PLANNING - LEVEL III REVIEW (14-526): MMC Congress Street Medical Building (285KSF) (19 procedure rooms, 64 patient rooms, licensed bed count remains 637)
Institutional Overlay Zone

IOZ - ZONING ANALYSIS

Preliminary Review (10/10/18)	
Transportation	a. Impact on Surrounding Street Systems	Traffic Movement Permit analysis to come pending scoping meeting

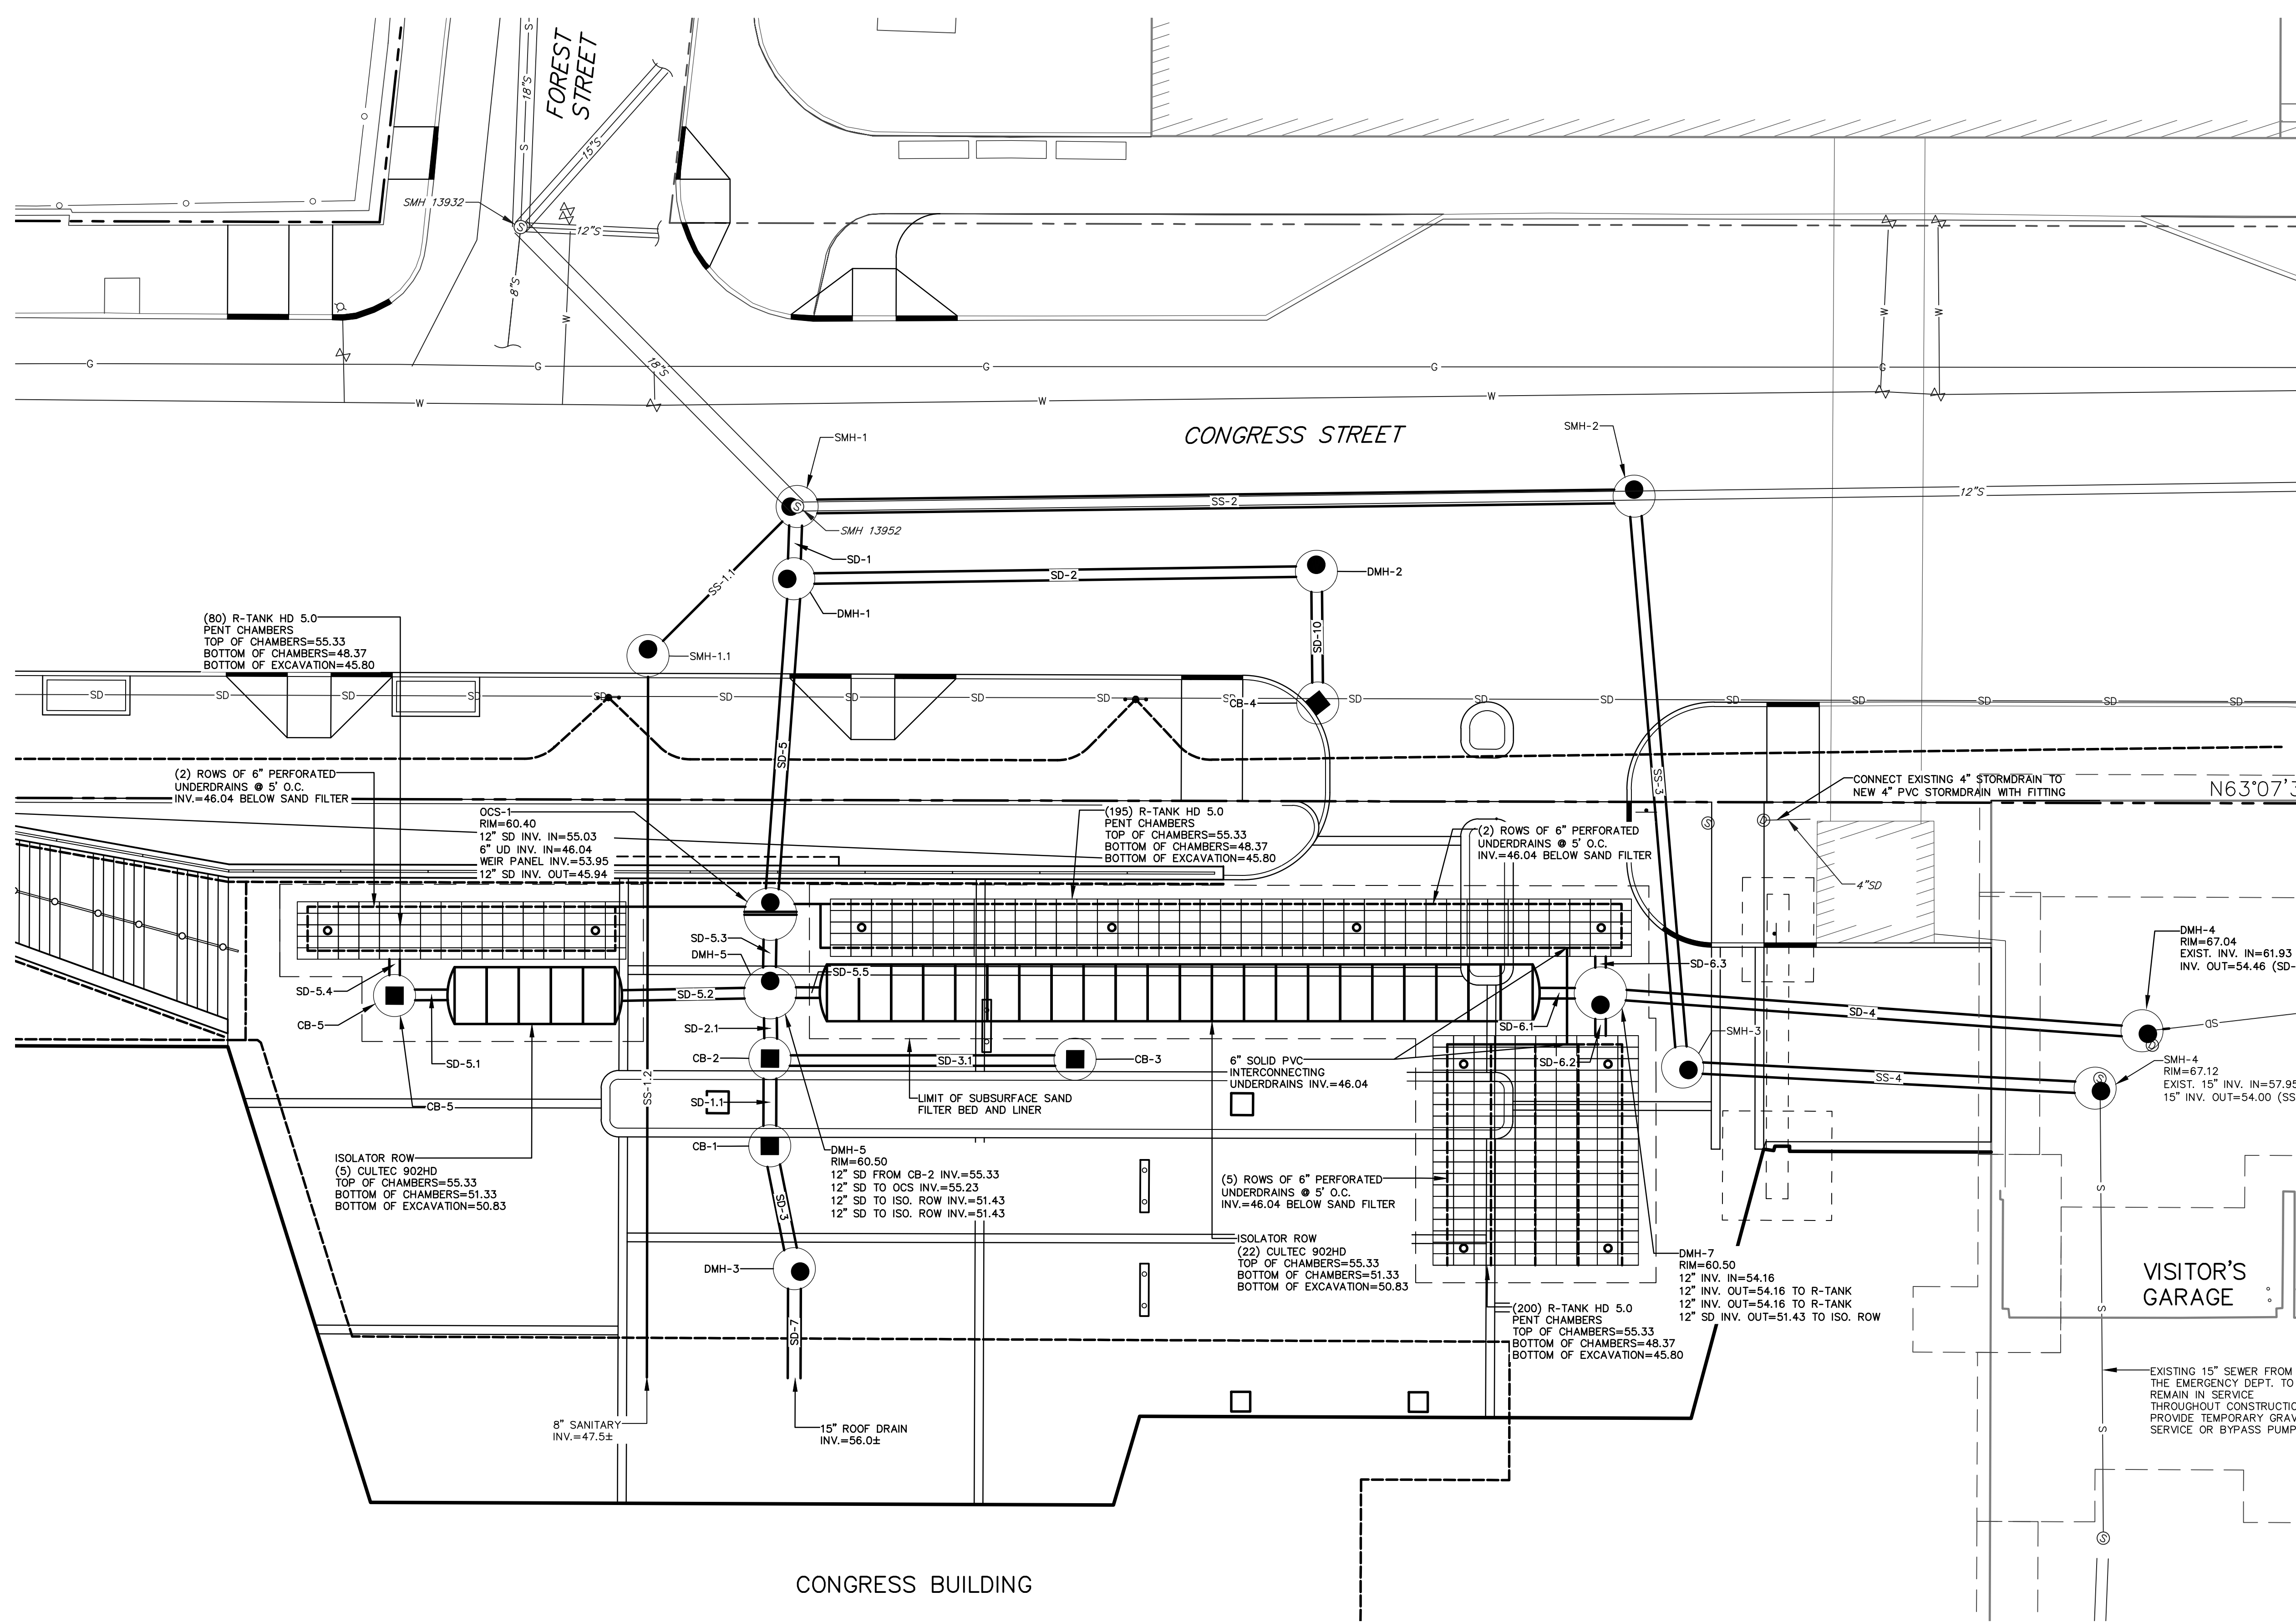
- rescale site plan at 1" = 20'
- include distances to property lines on site plan
- add height calculation from average grade on elevations
- plans need to be stamped by an engineer

Encroachments (building and 'mechanical areaway') into Gilman ROW need further review.

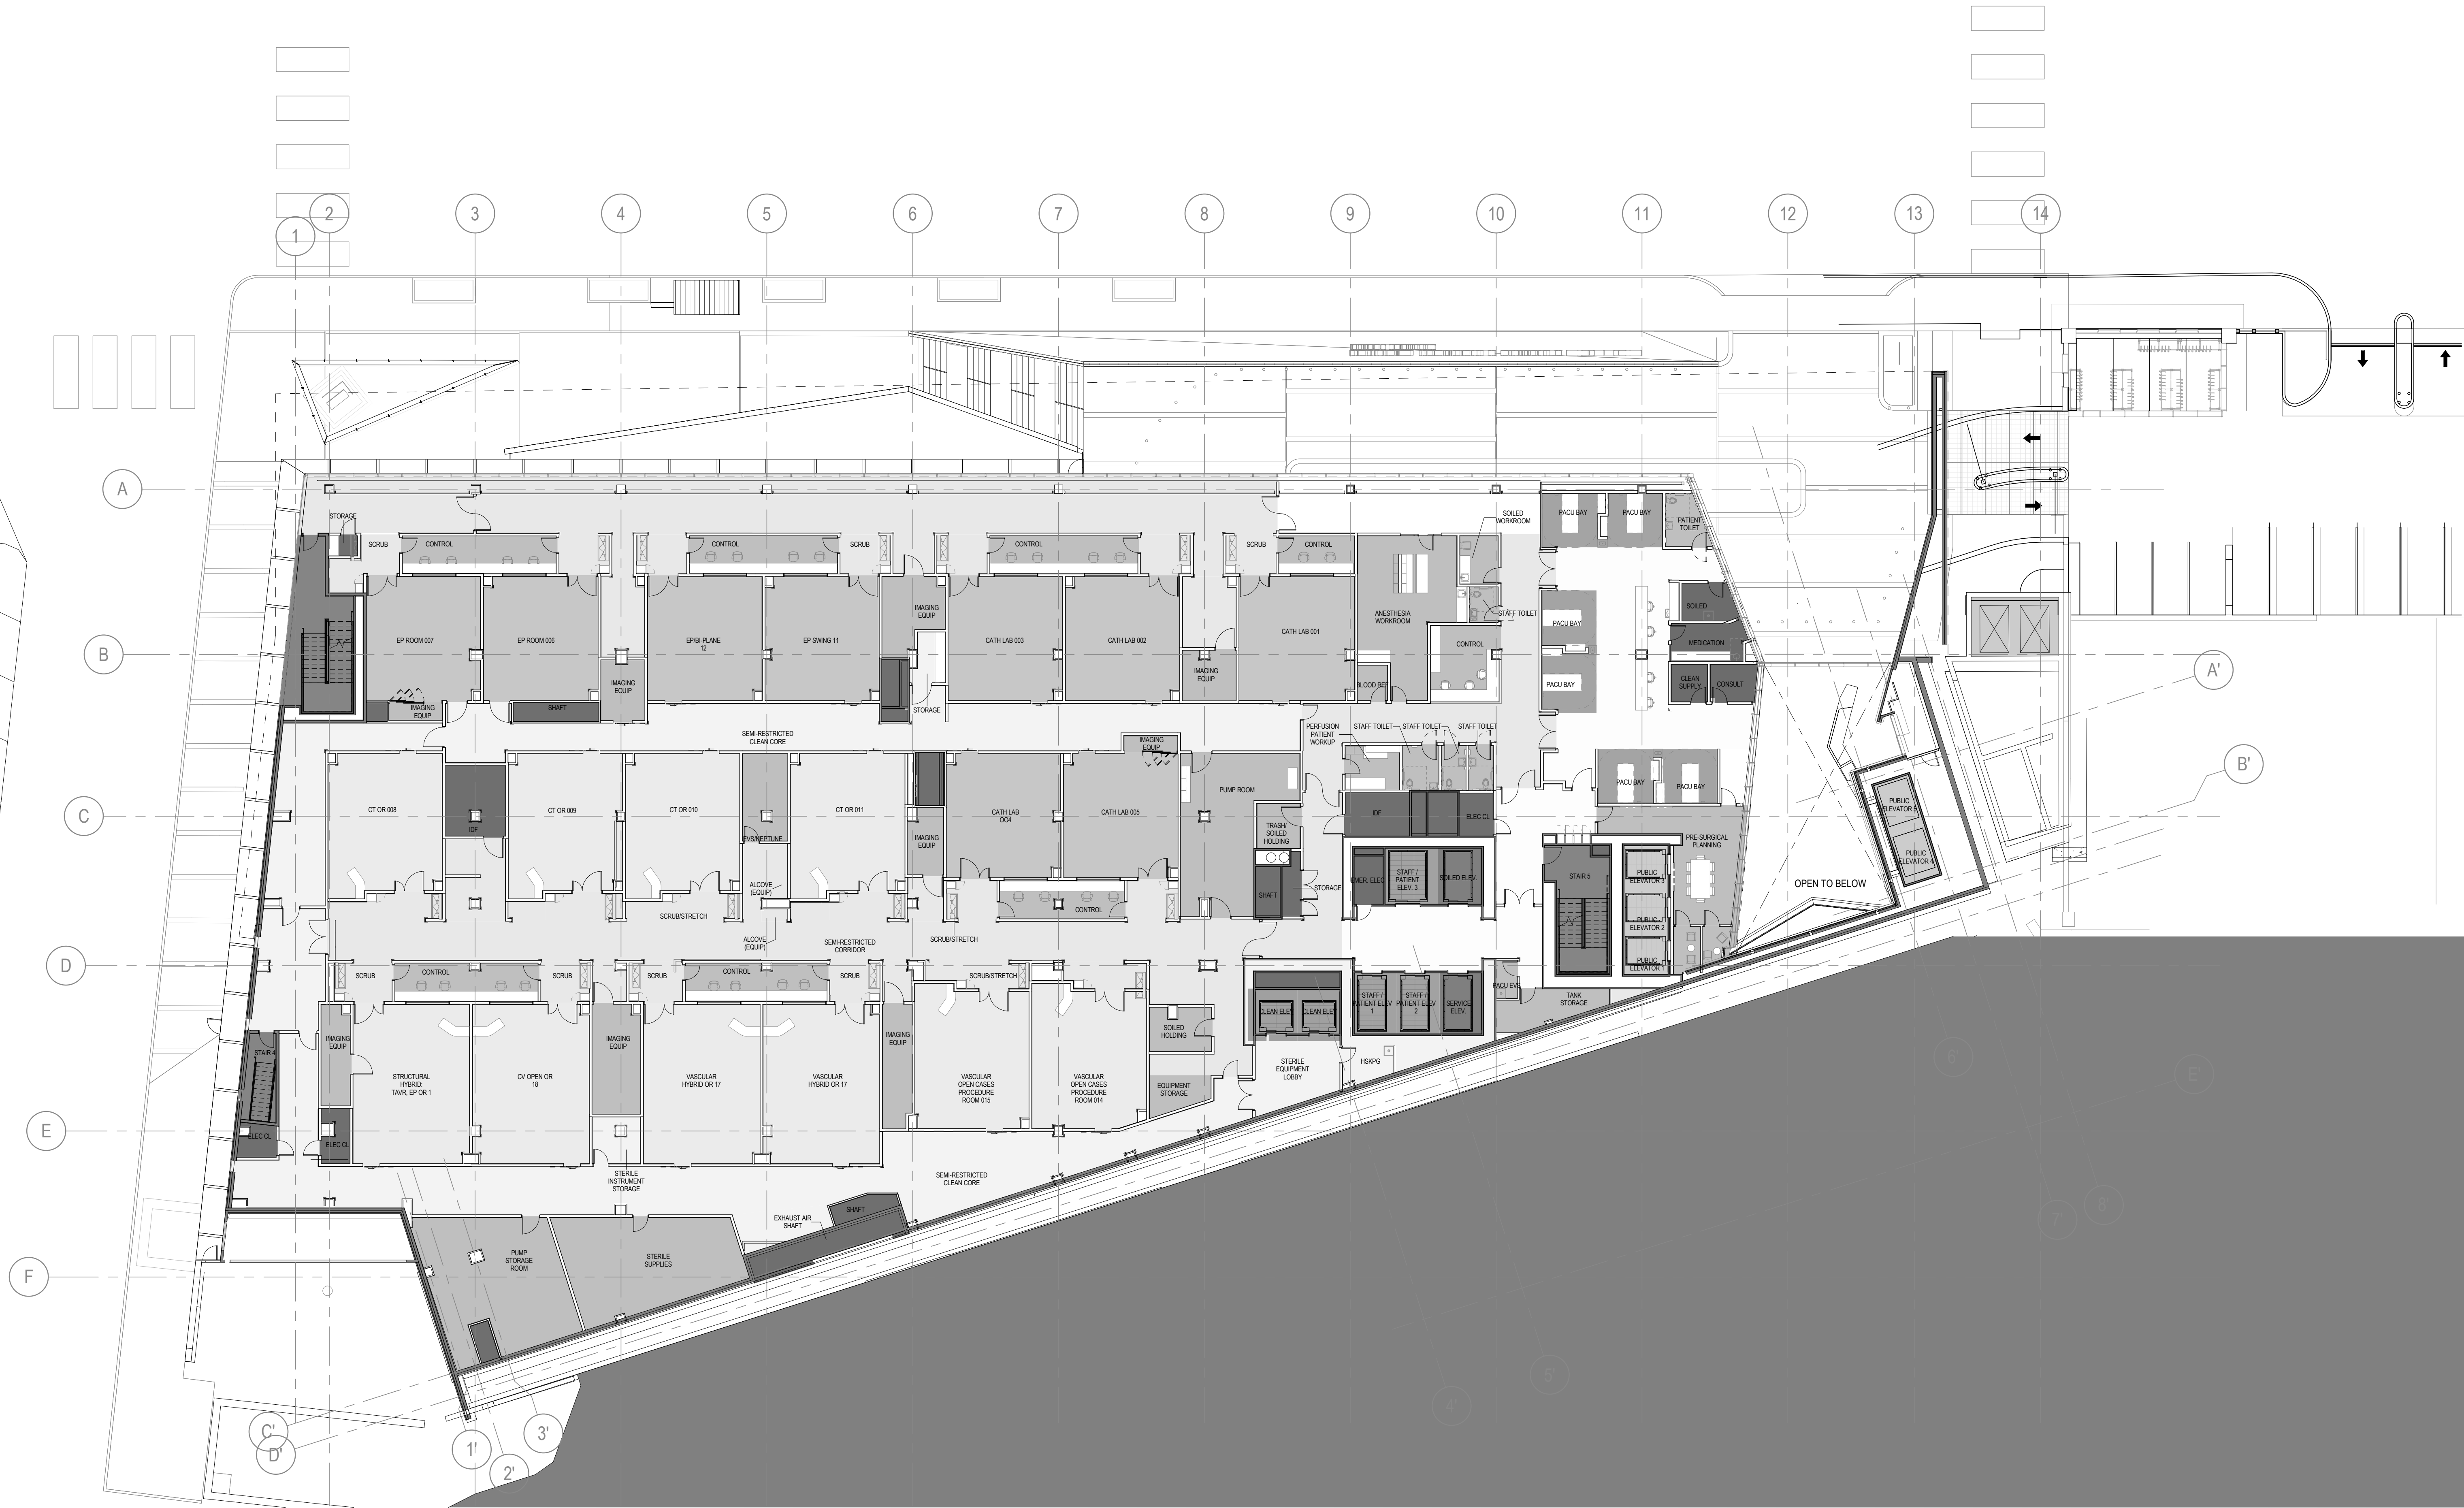
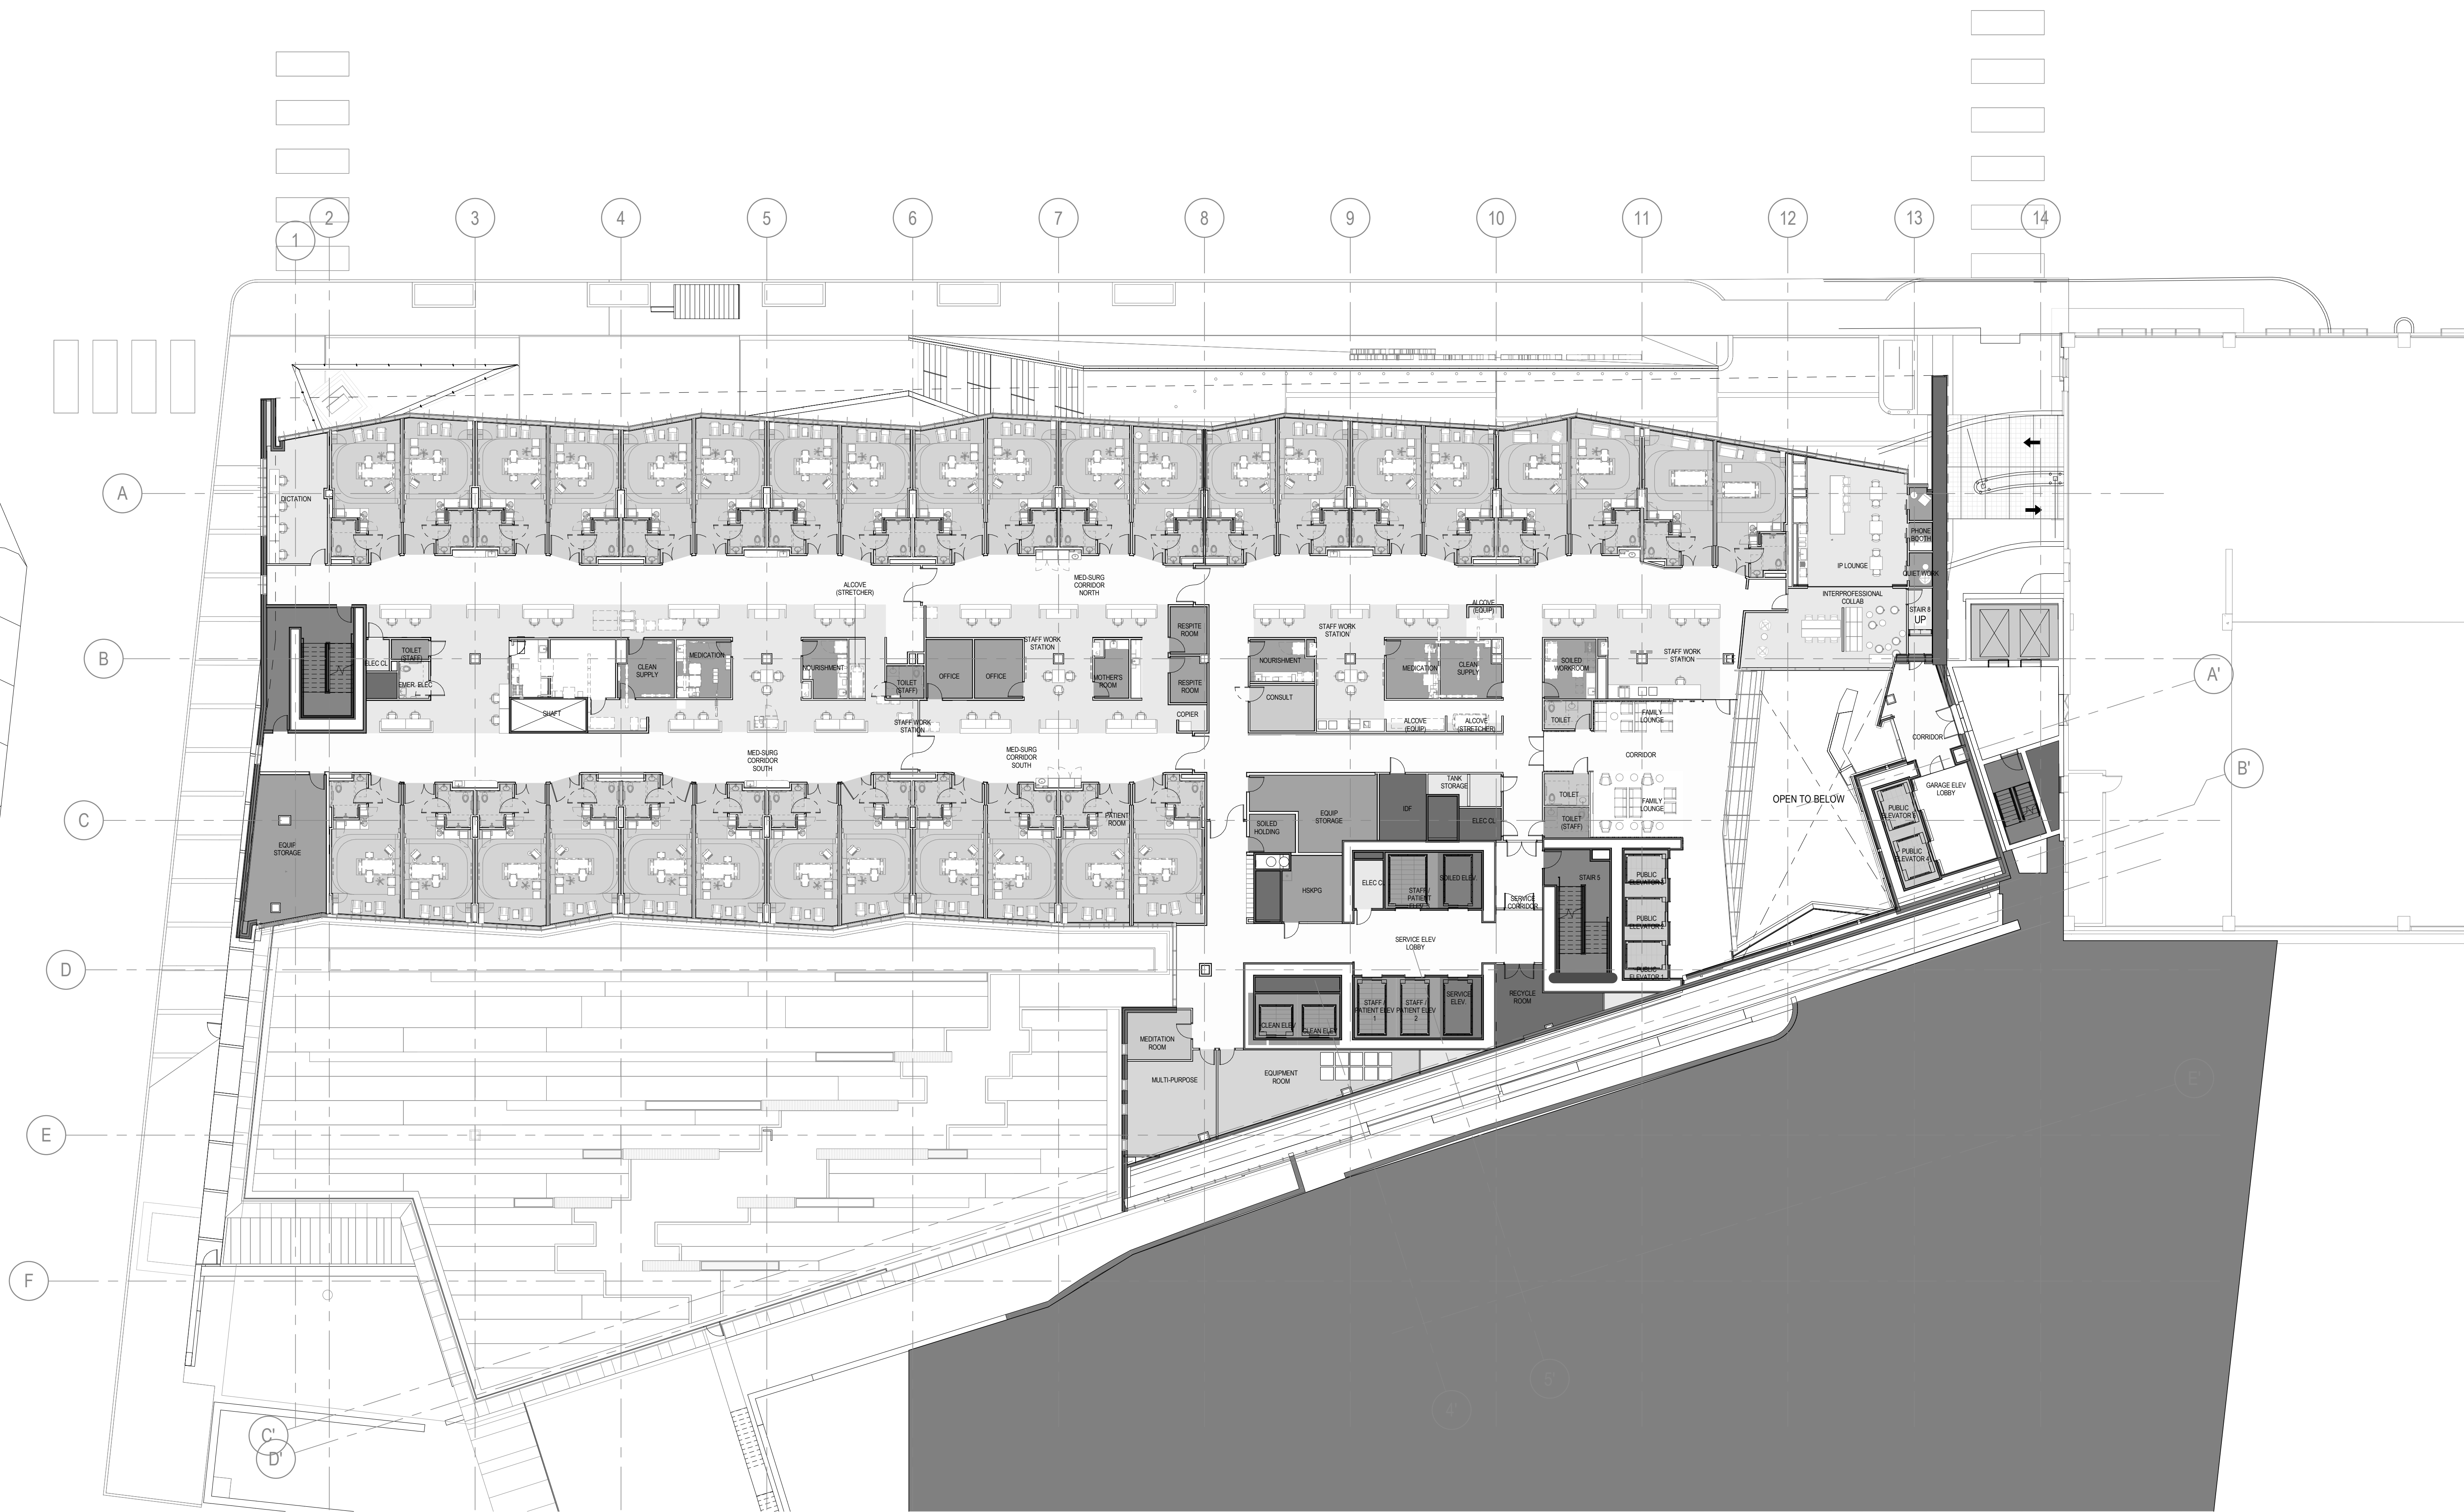
- a. *Use*
- b. *Dimensional Requirements*
Provide analysis with respect to dimensional requirements in the revised submittal.
- c. *Design*
See comments by others.
Please provide floor plans in revised submittal
- d. *Signs*
See below.
- e. *Transportation*
- f. *Environment*
- g. *Mitigation Measures*
- h. *Neighborhood Integration & Neighborhood Engagement*
- i. *Construction Management*
See comments by others.
Please provide some discussion on attempts to minimize impacts to pedestrian circulation along the south side of Congress Street. Could sidewalk closure be limited to certain construction/demolition phases?
Provide discussion on bike accessibility around the construction site.
- j. *Other*
